COMMUNITY & NEIGHBOURHOOD OBJECTION SUBMISSION

Application Ref: SSD-81426710 (Amended Mixed-Use Development, 138 Maroubra Road)

Submitted By: Combined Adjoining Neighbors & Surrounding Community Members

DRAWN BY	SCALE	SHEET SIZE	PRINT DATE
Author	1 : 500	A1	18/09/2025
DESCRIPTION			
SHADOW DIAGRAM PLANS			
SHEET 3			
PROJECT No	DRAWING No	REVISION	
21_435	DA8.302	I

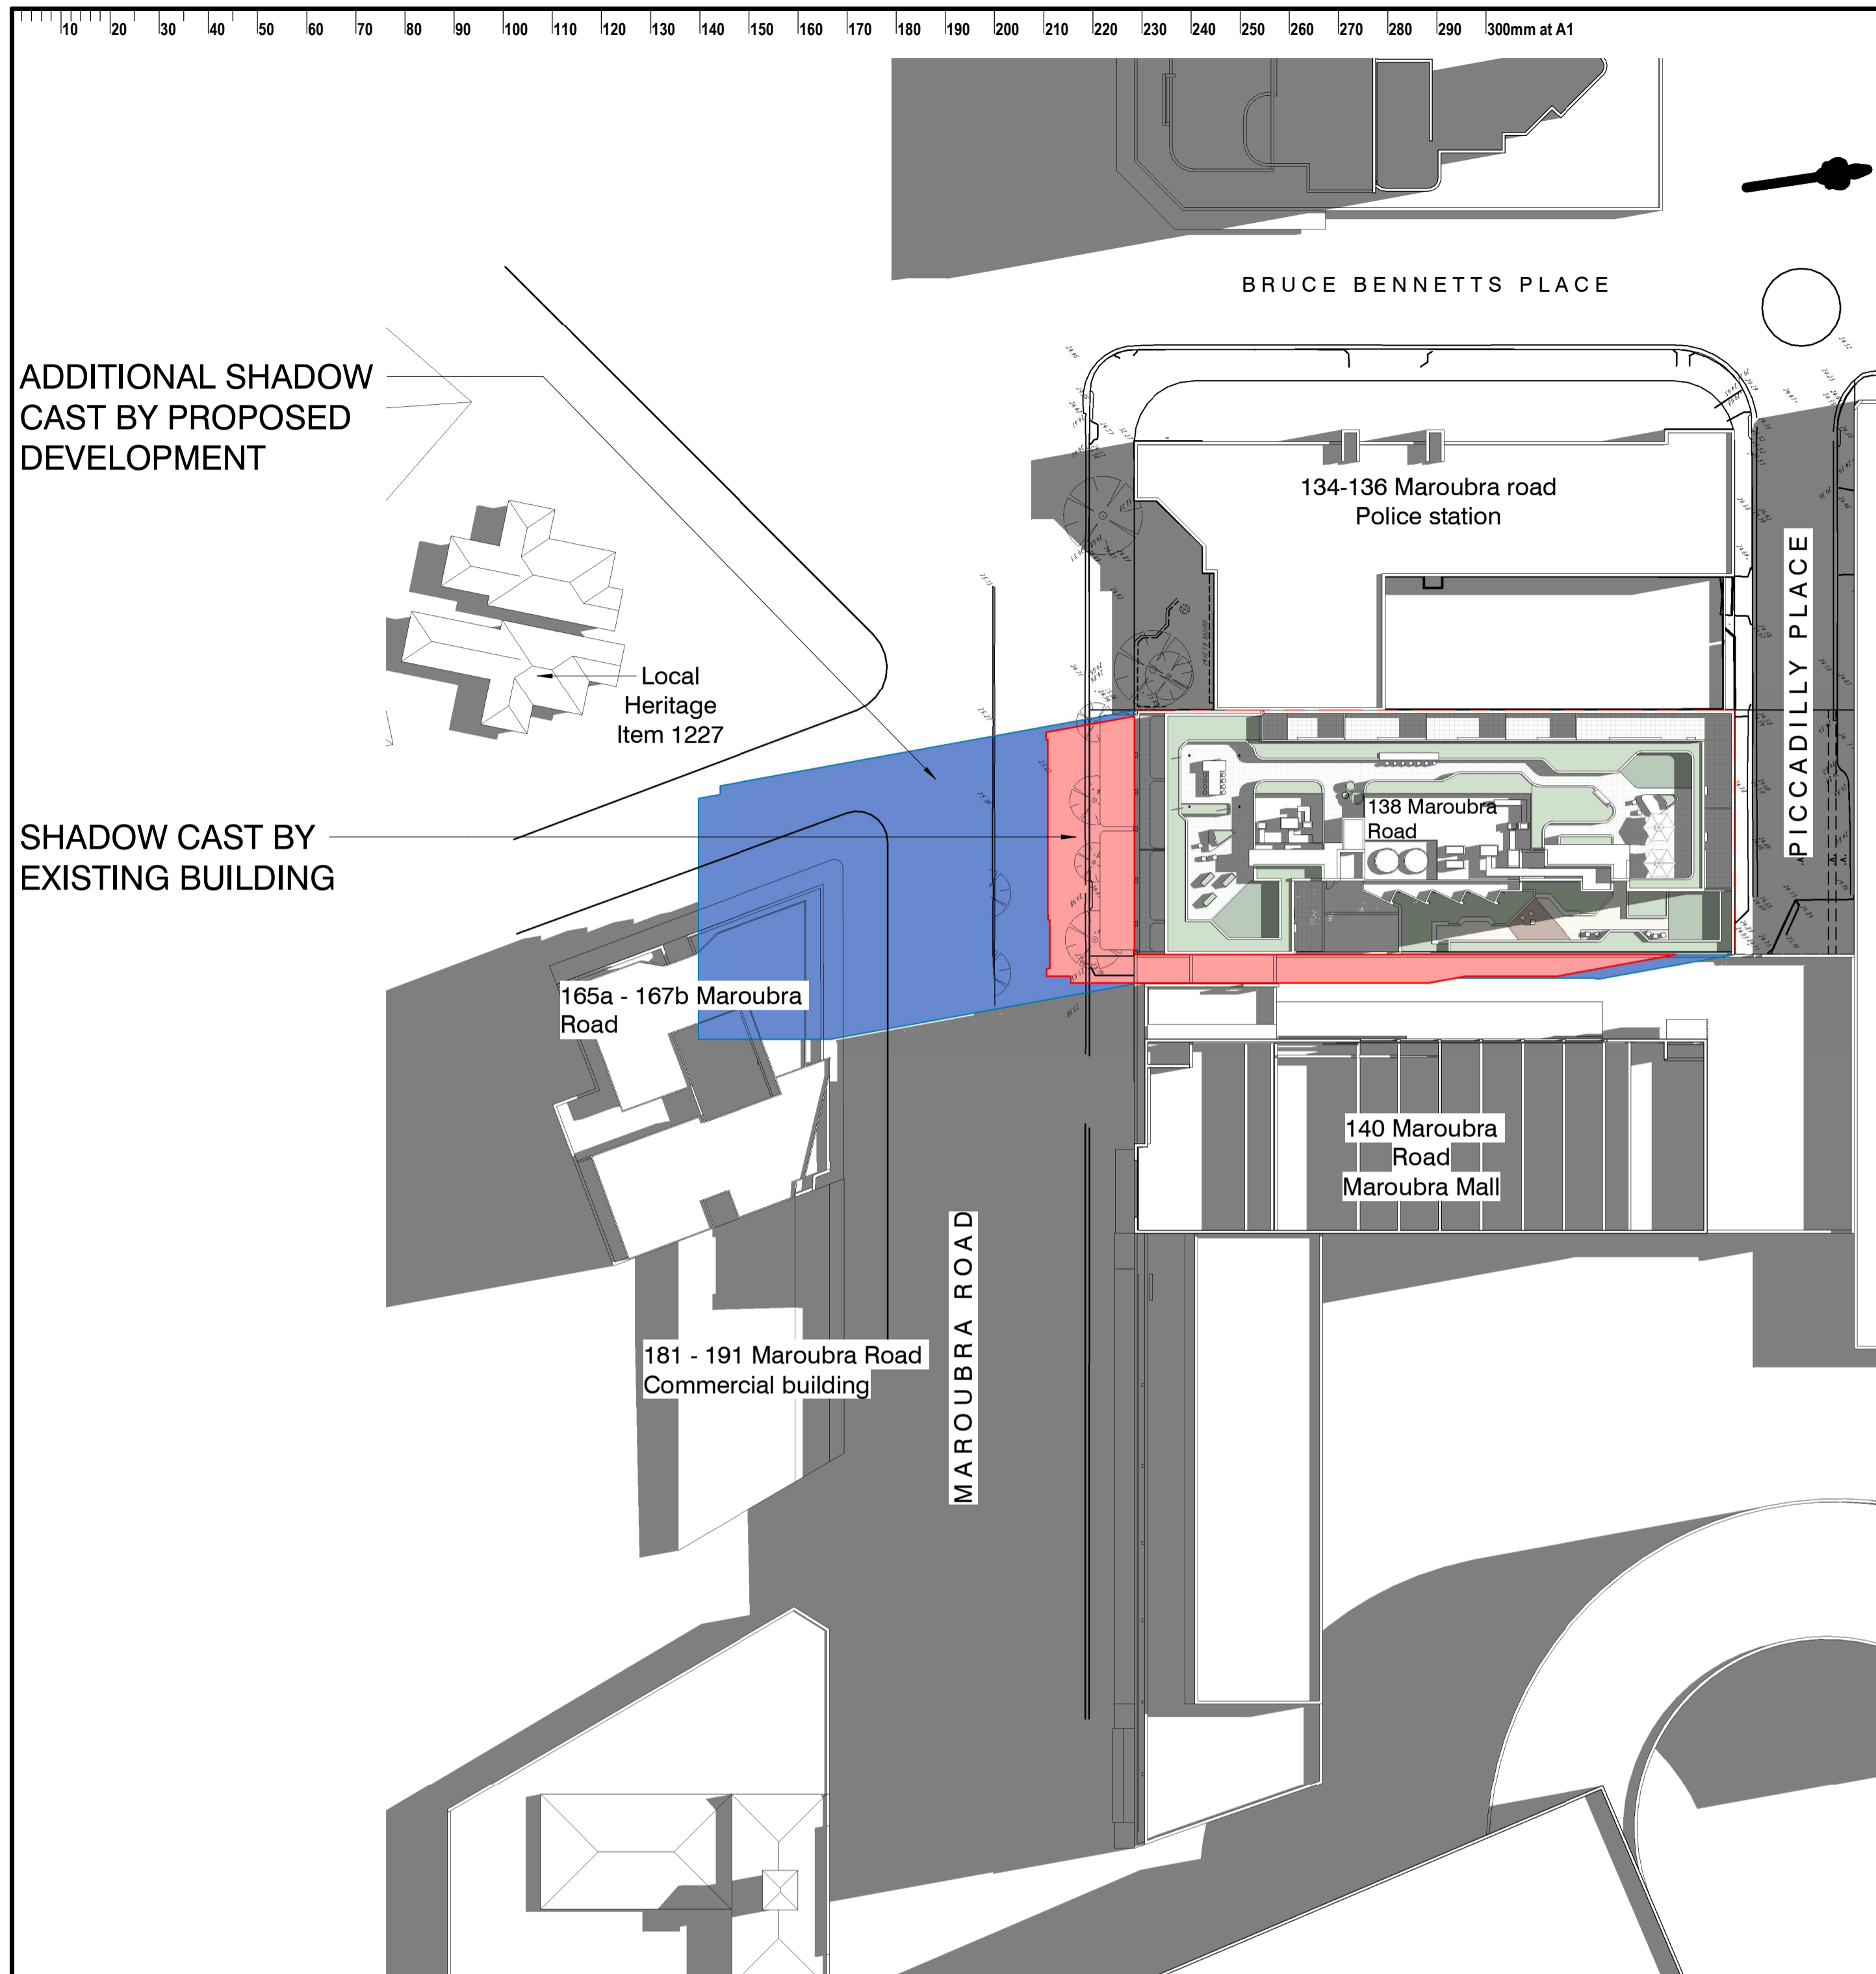
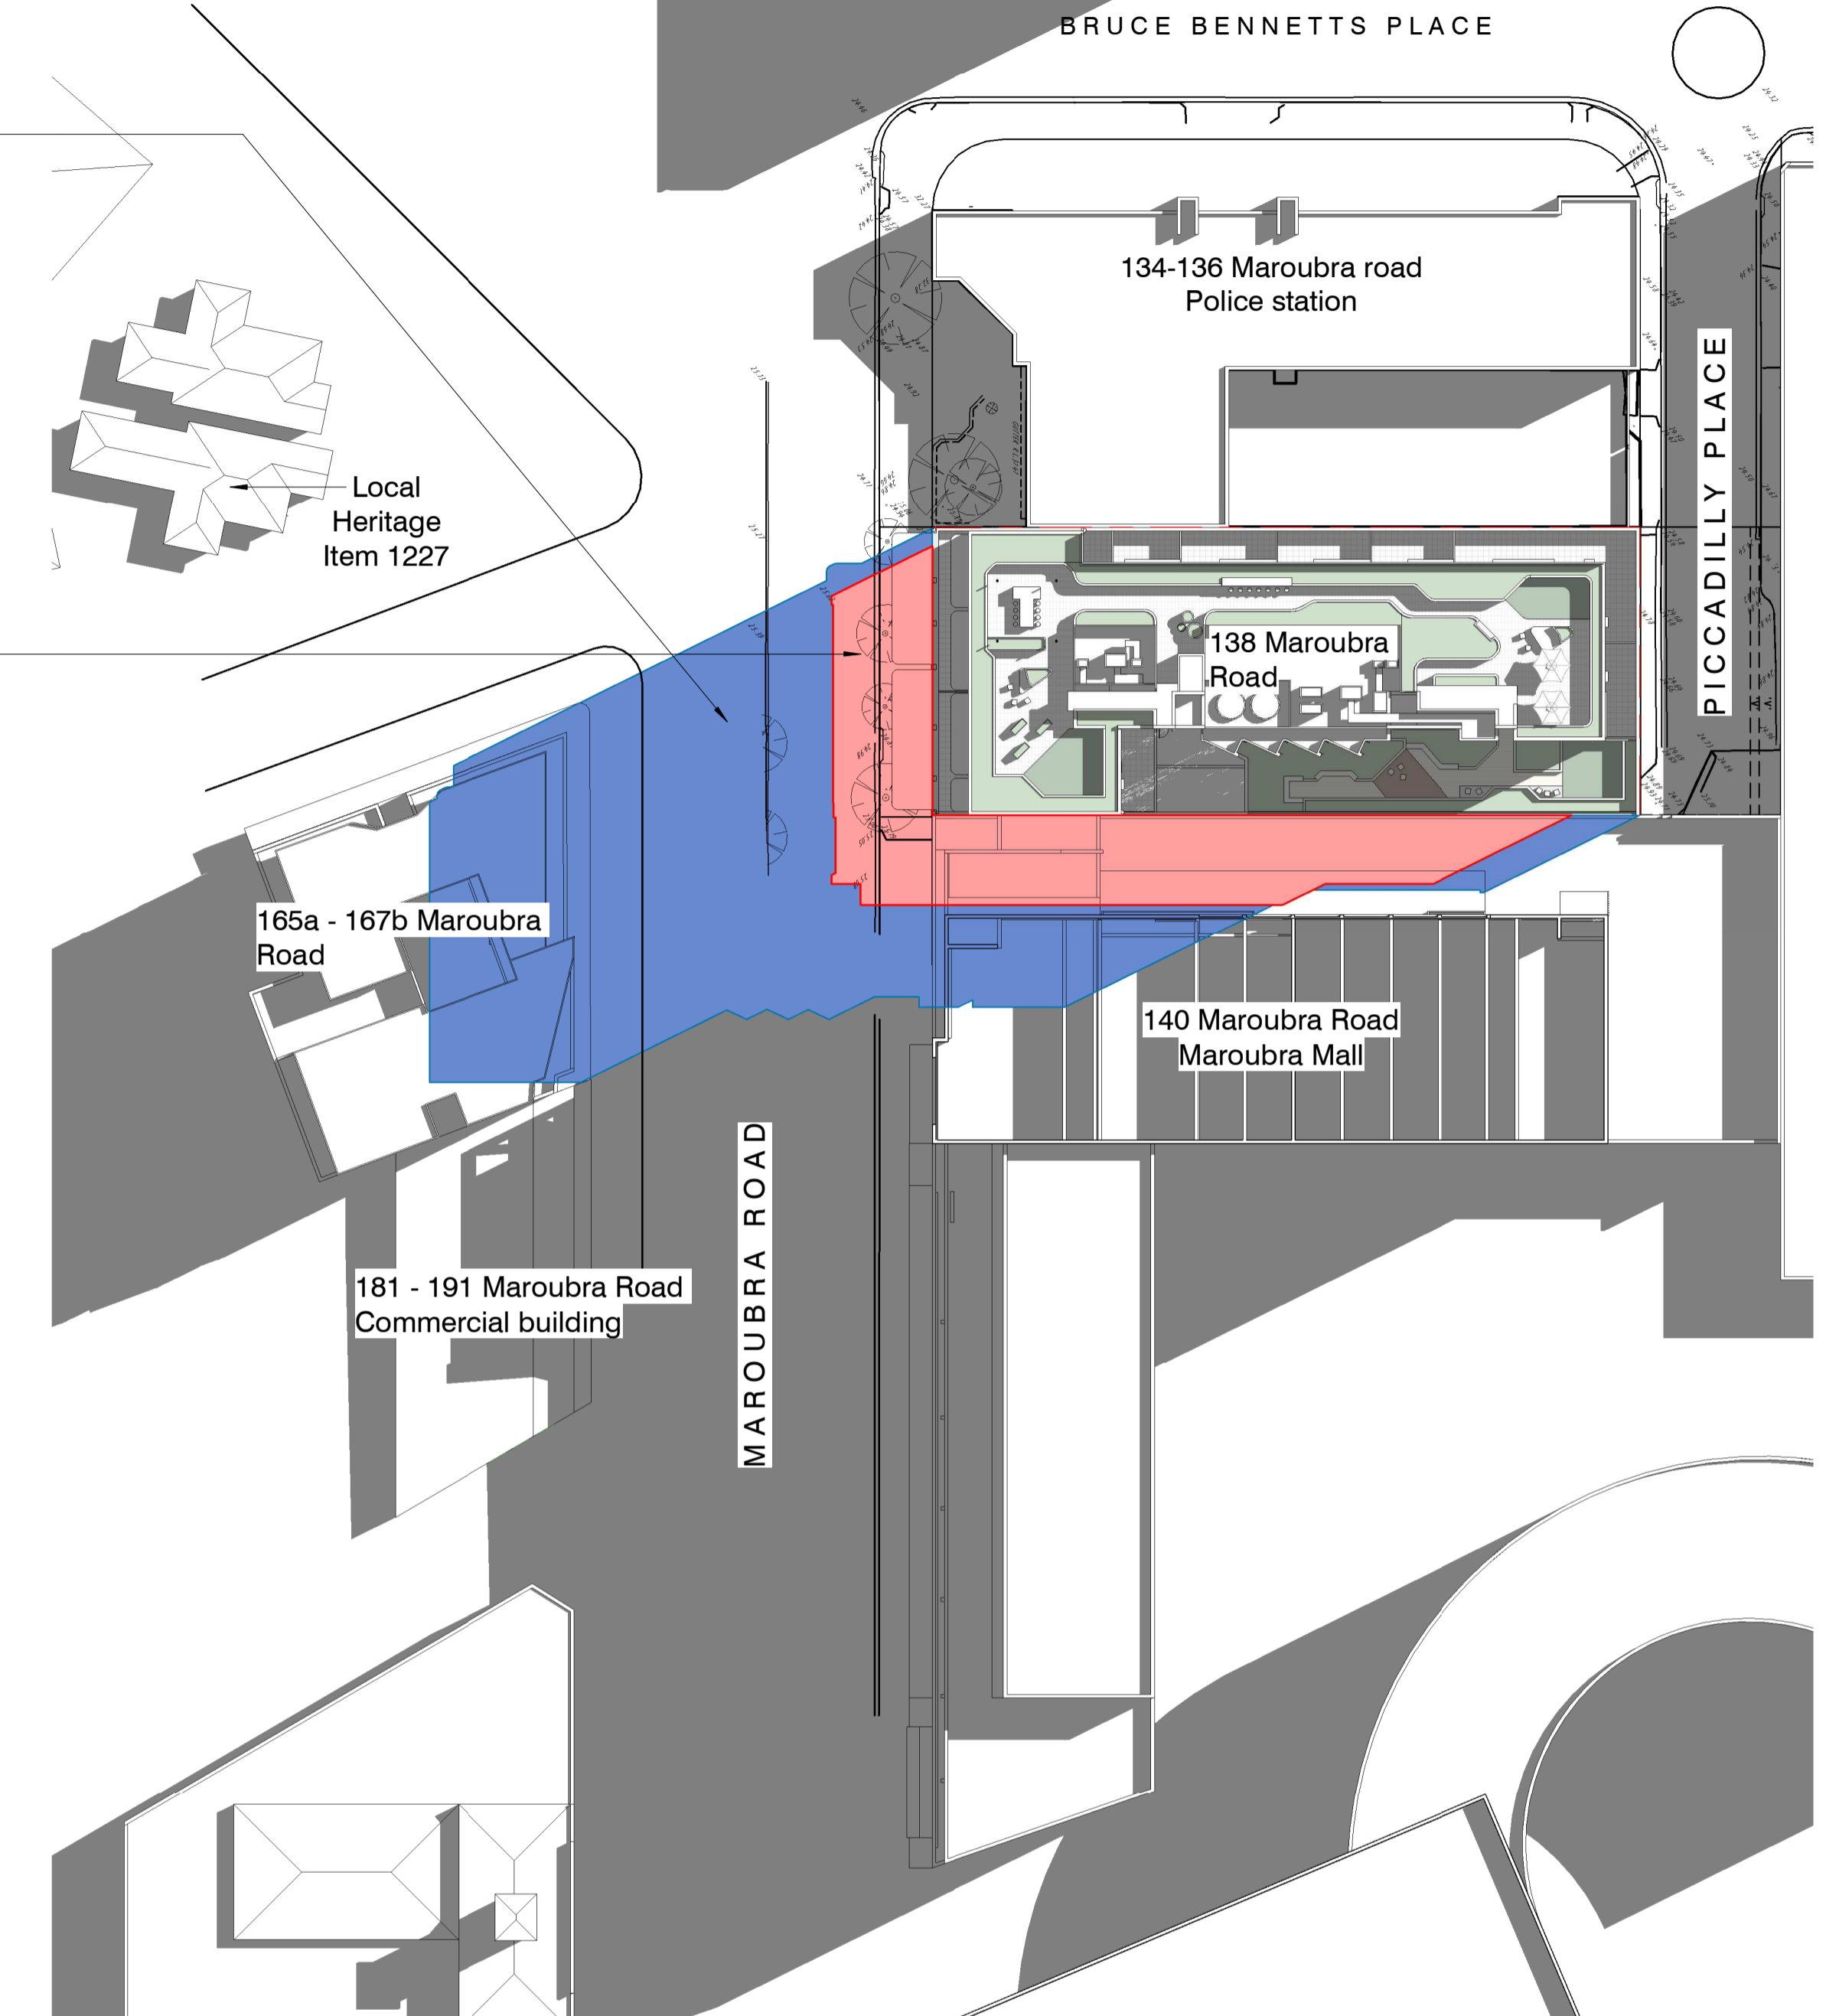
The developer's updated shadow modeling relies on broad, generic regional assumptions under the Apartment Design Guide (ADG), completely brushing aside the microclimatic impact on immediate neighbors. Erecting a deep, unarticulated 10-storey concrete structure directly to the west will plunge adjacent properties into darkness during crucial afternoon hours.

Access to natural daylight is a fundamental component of livability and passive room heating. Depriving surrounding homes of afternoon sunlight directly degrades the health and physical well-
